WATERSIDE AT LAKE WOODMOOR FILING NO. 1

CONSTRUCTION PLANS

FEBRUARY 2023

EPC STORMWATER REVIEW COMMENTS
IN ORANGE BOXES WITH BLACK TEXT

WATERSIDE AT LAKE WOODMOOR			
FILING NO. 1			
GRADING AND EROSION CONTROL PLAN			
DESIGNED BY	MAL	SCALE	DATE 02/09/23
DRAWN BY	ME'S	(H) 1" = 30'	SHEET 2 OF 14
CHECKED BY	(V) 1" = N/A	JOB NO.	2588.00

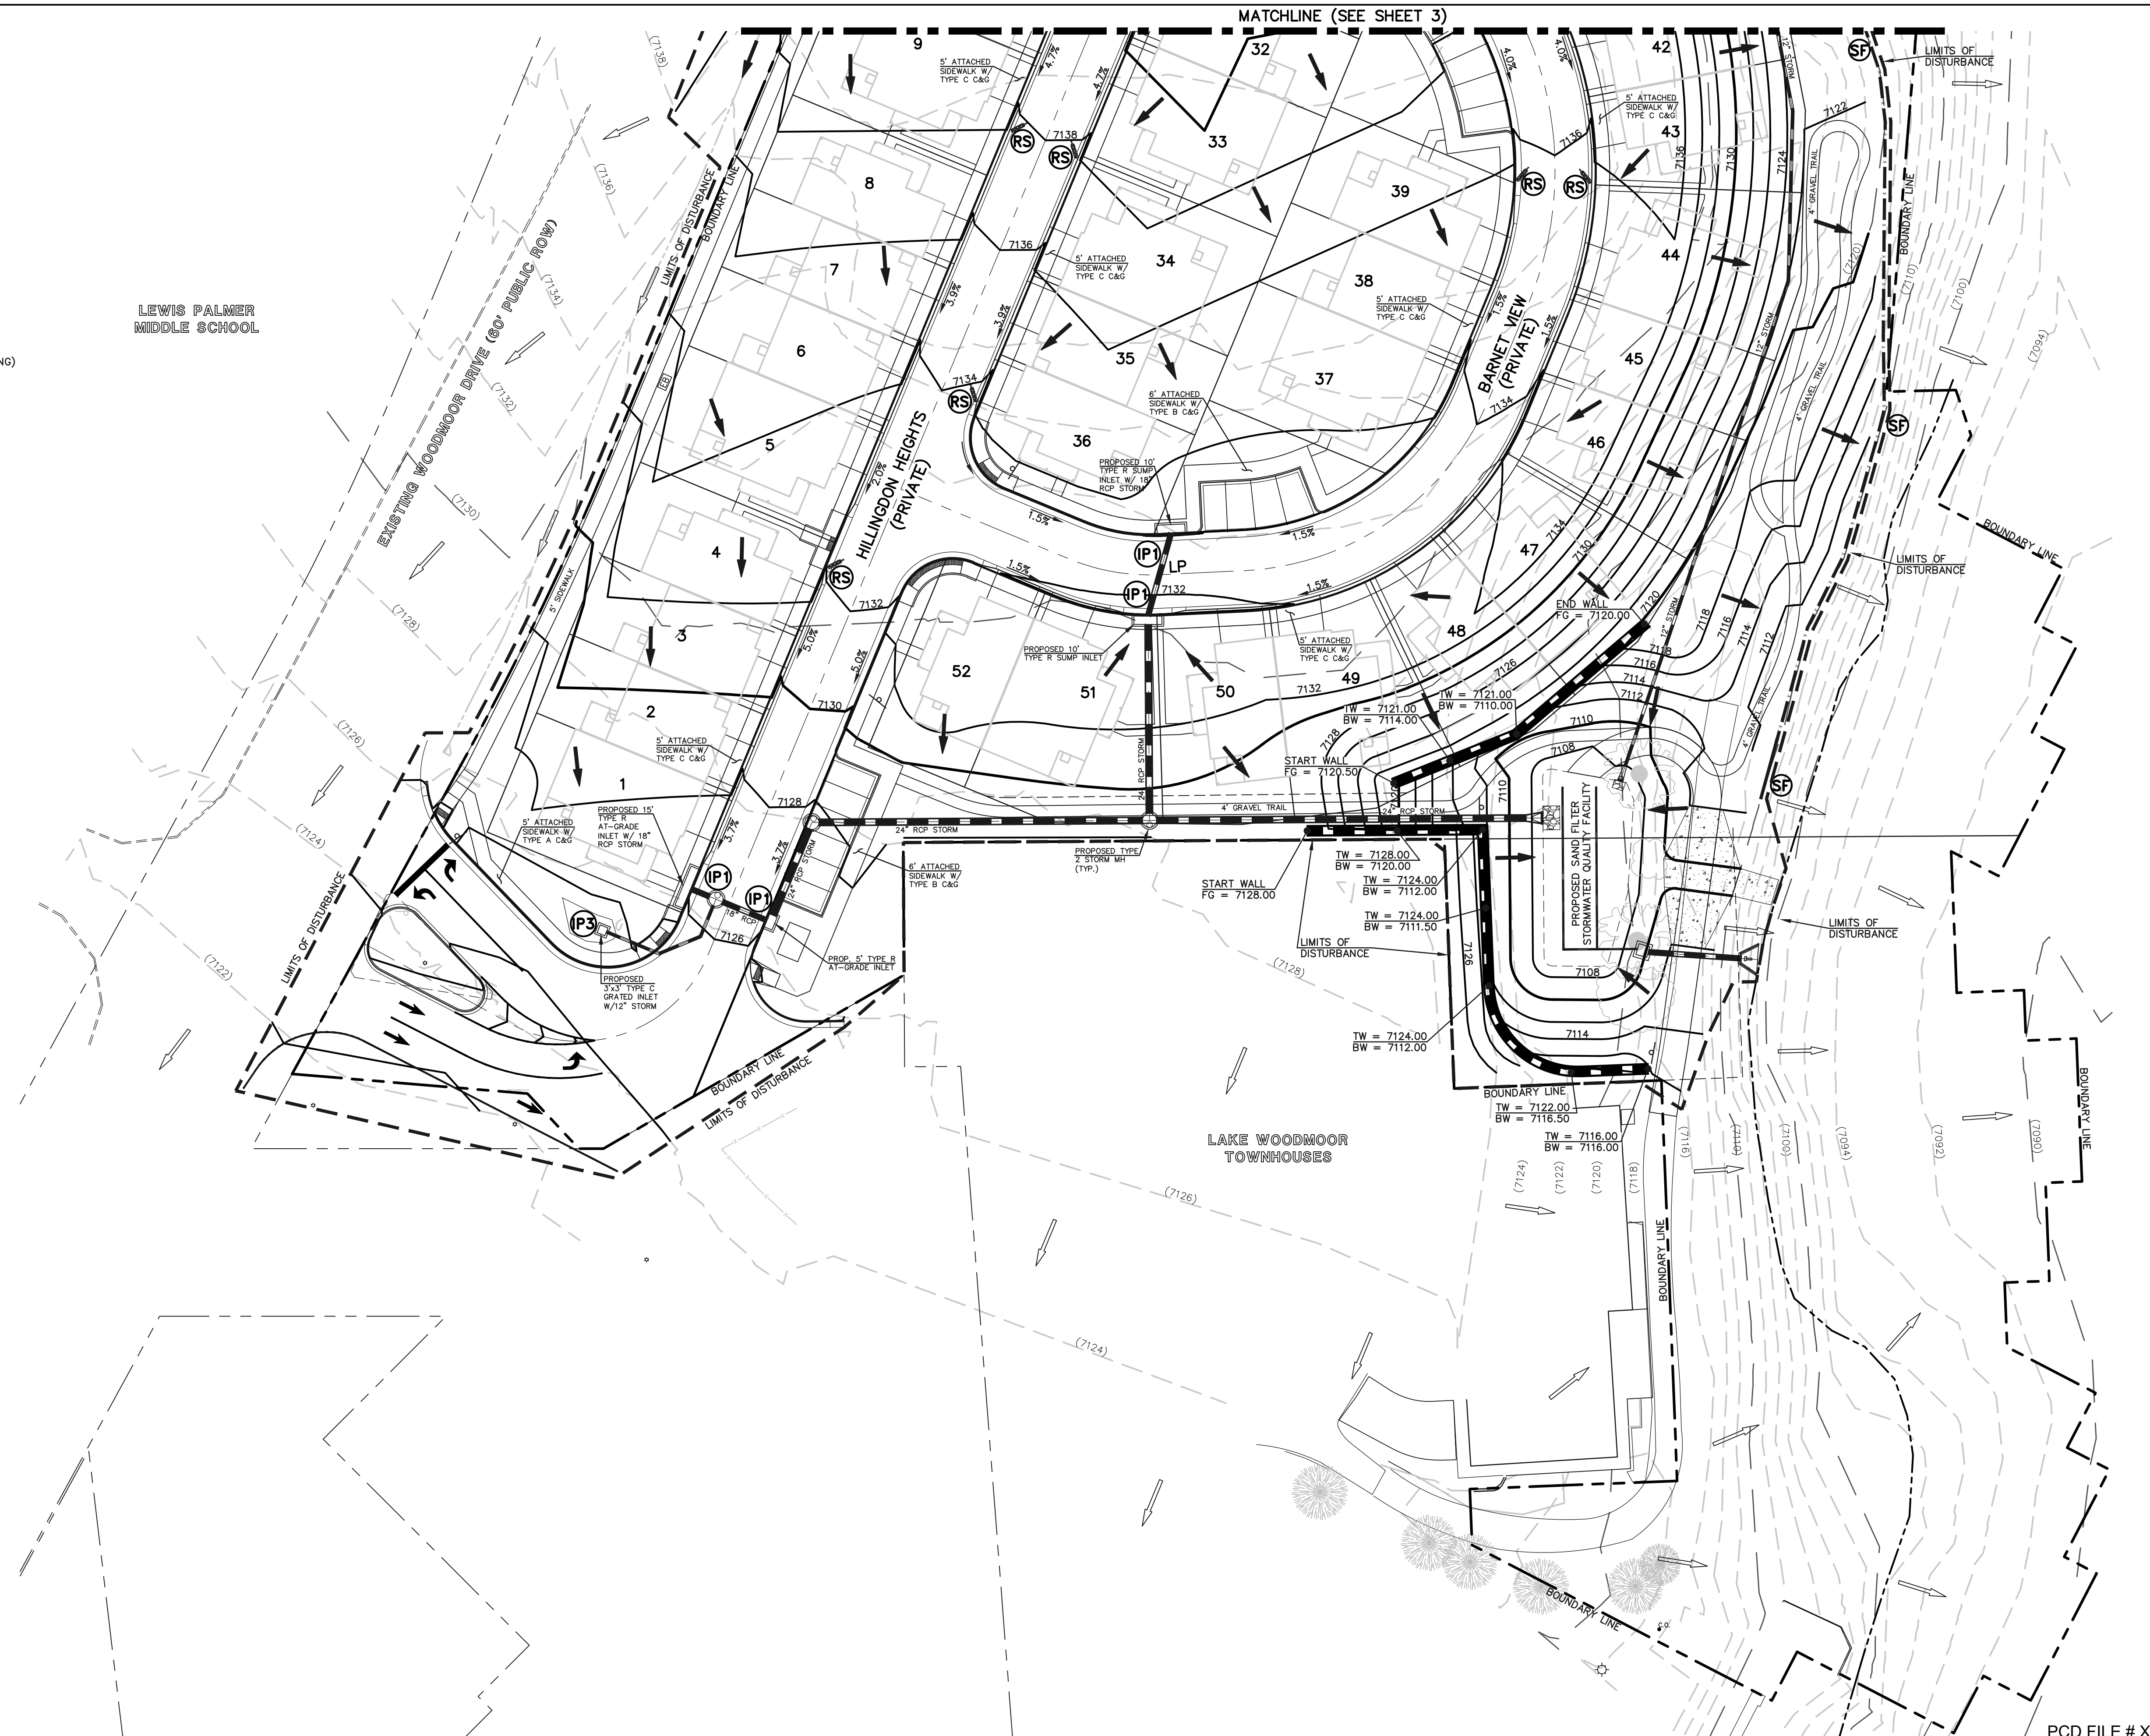
show areas of cut/fill

Show seeding area on plan and include hatch in legend

As these plans are for the early grading request, do not show roads, lots, etc. Only include grading and items being constructed with grading activities. Is Pond or storm sewer being built with early grading? Will additional swales be needed to convey flows through site until roads, c&g are built? Will additional TSB's be needed?

GEC Checklist Item W. Provide construction fencing, barricades, and/or signage at access points not to be used for construction.

GEC Checklist Item O. This looks to be offsite grading. Need owner permission to grade offsite. Provide copy of owner permission to EPC

add property owner information

Note: Structural plans will need to be provided for walls greater than 4 ft in height

call out fema 100yr and woodmoor lake on figure

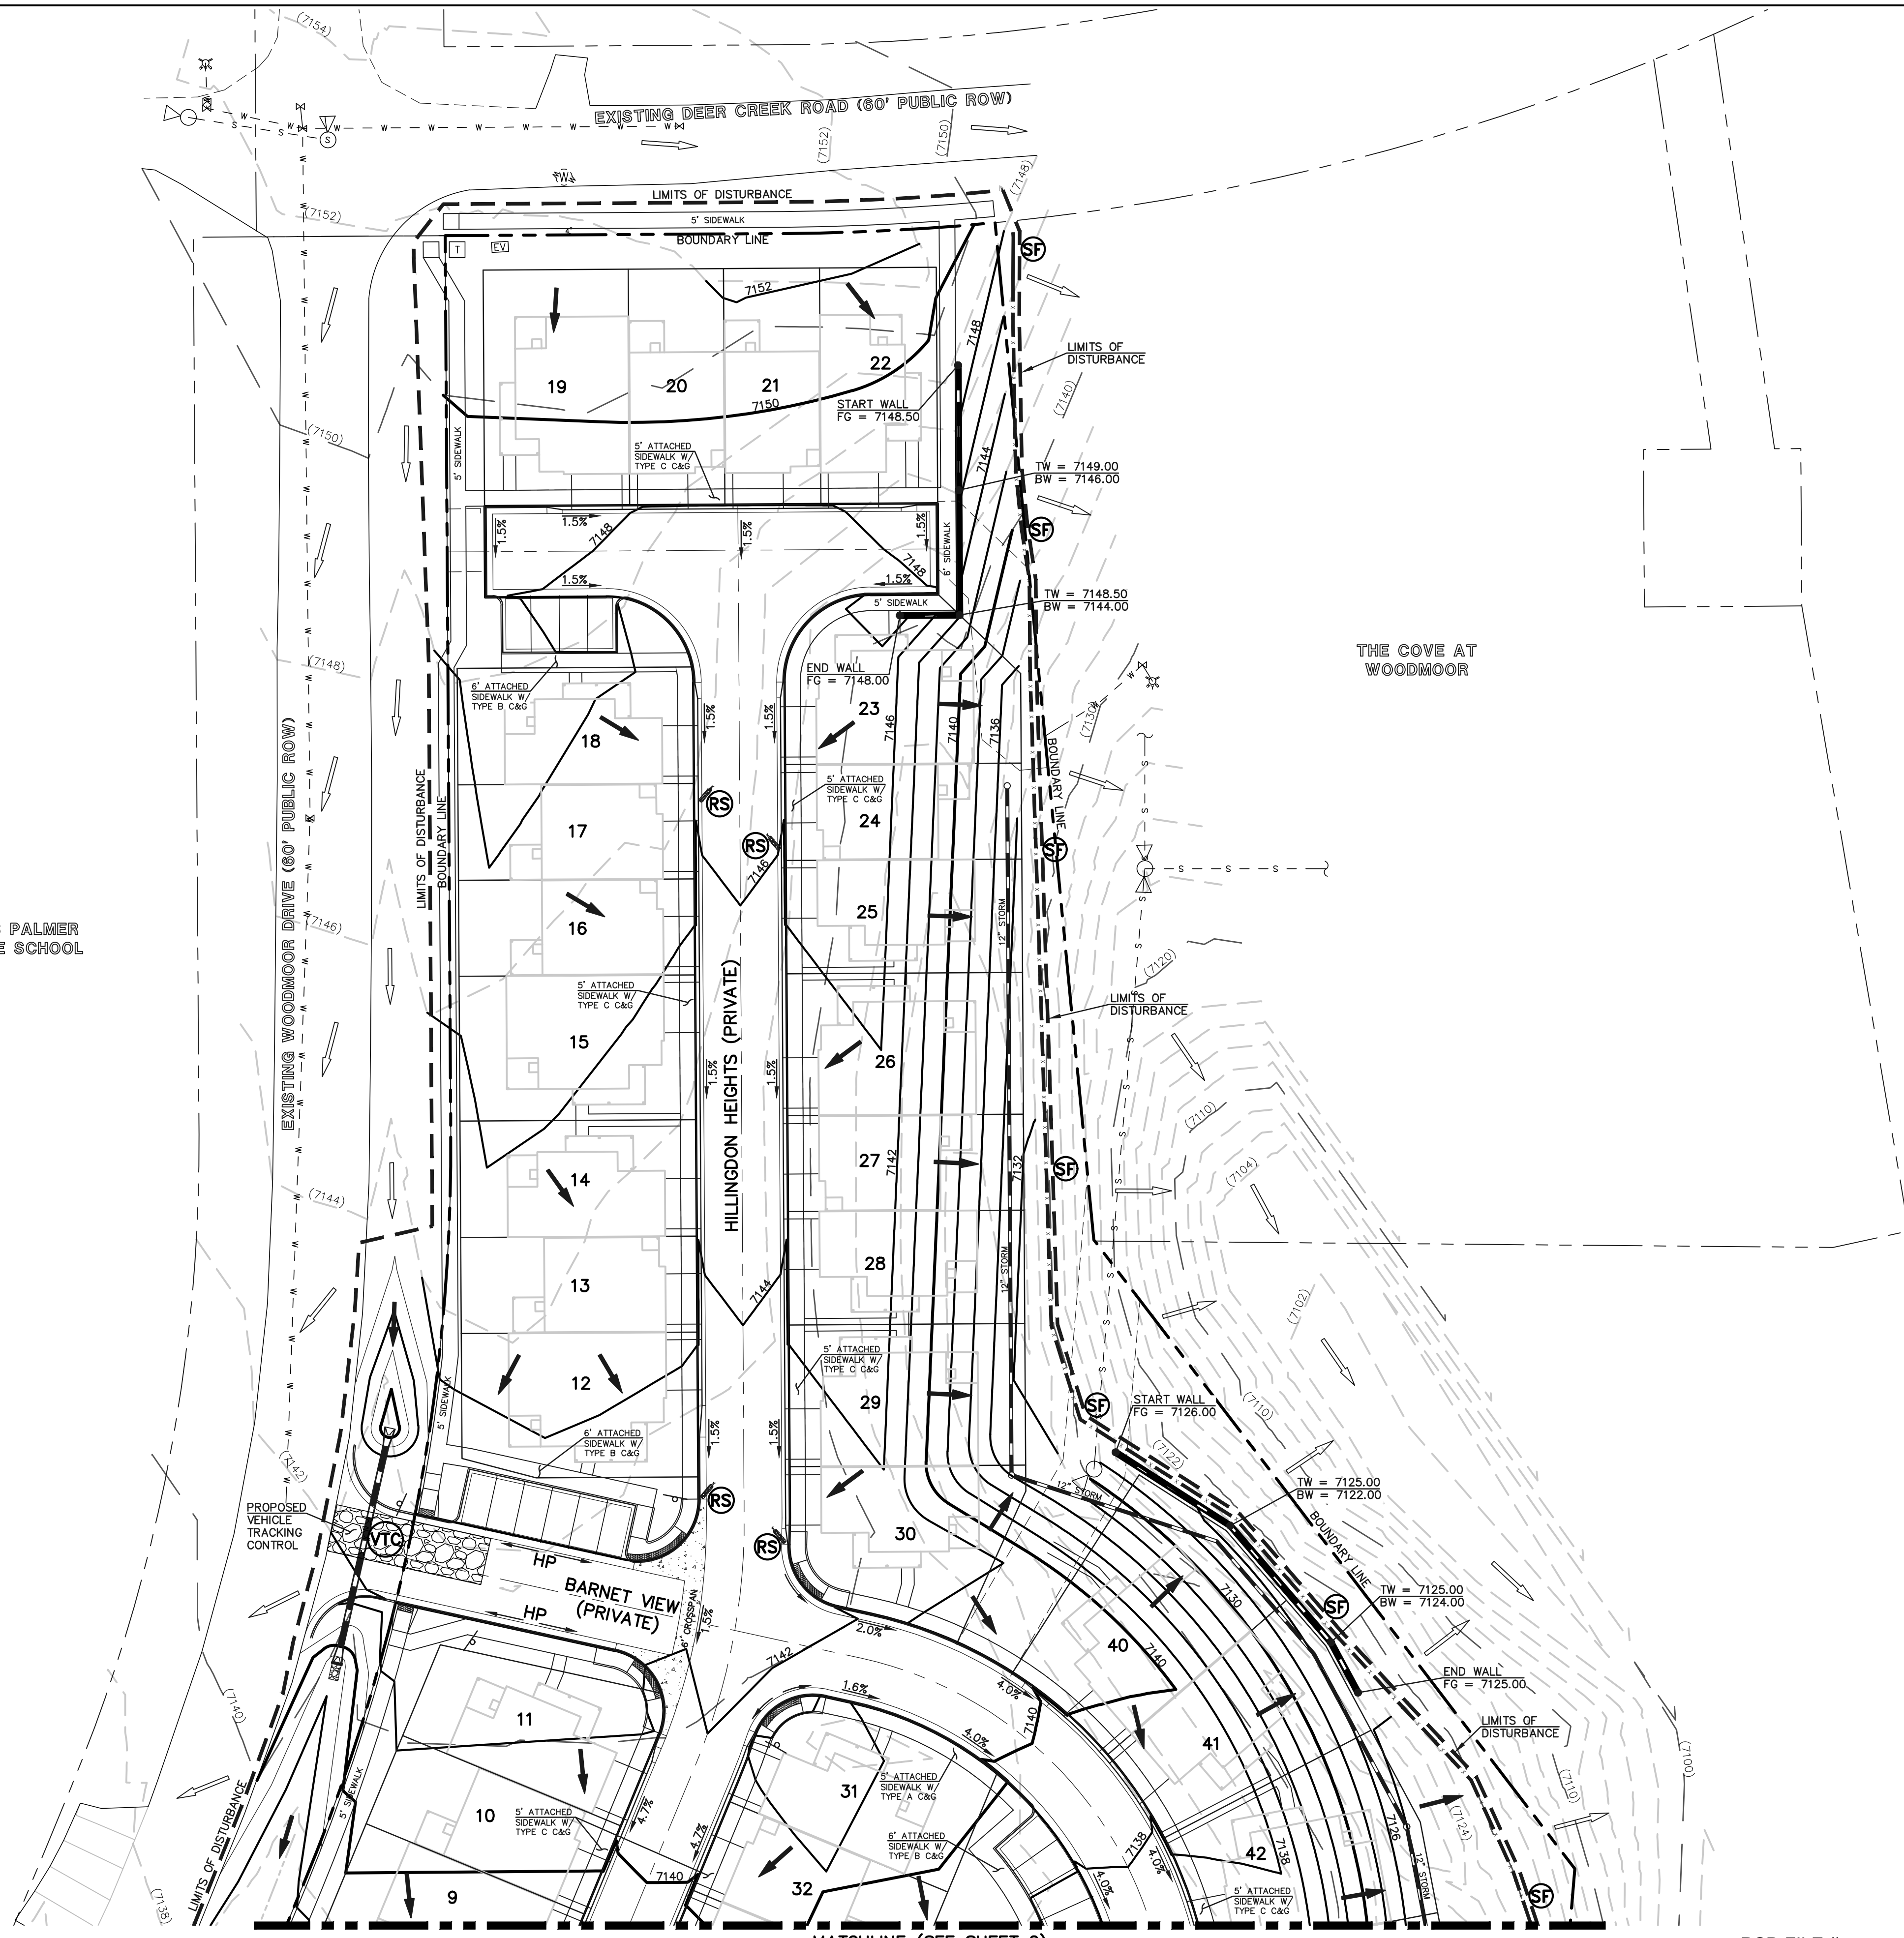
show areas of cut/fill
 show concrete washout basin location
 show staging area

show all areas of seeding (final)

Provide details of temporary sediment basin including riser pipe diameter and perforation sizing, number of rows of holes, required volume, location of outlet pipe and spillway, and tributary area to the sediment basin. And provide contours for sediment basin.
